Your Ref: OWPC14678
Our Ref: AW/155/17/PL 16-05-2017
Please ask for:
Mr S Davis

Erection of 1No. detached dwelling. This application affects the character and appearance of Craigweil House Aldwick Conservation area
Land to the side of Brus Lodge 28 Kingsway Aldwick

Thank you for your internet representation made on 24th July 2017 which has been recorded as '**an objection**' with the comments as follows:

Dwg No  
PL25

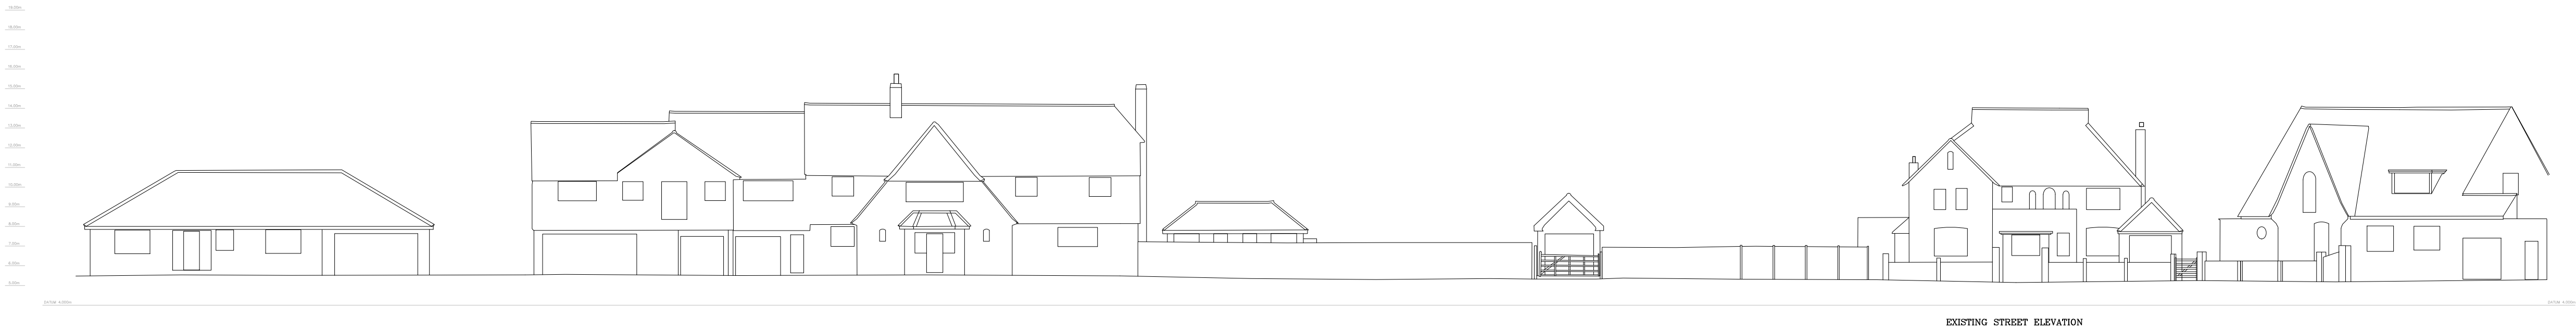
The latest Street View document TSP 481 PL25 REV 8, gives a total misrepresentation of the street scene. Looking directly in front of the proposed development you cannot see the western side of Number 22. The boundary in front of Number 22 onto the CPEL verge is again misrepresented.
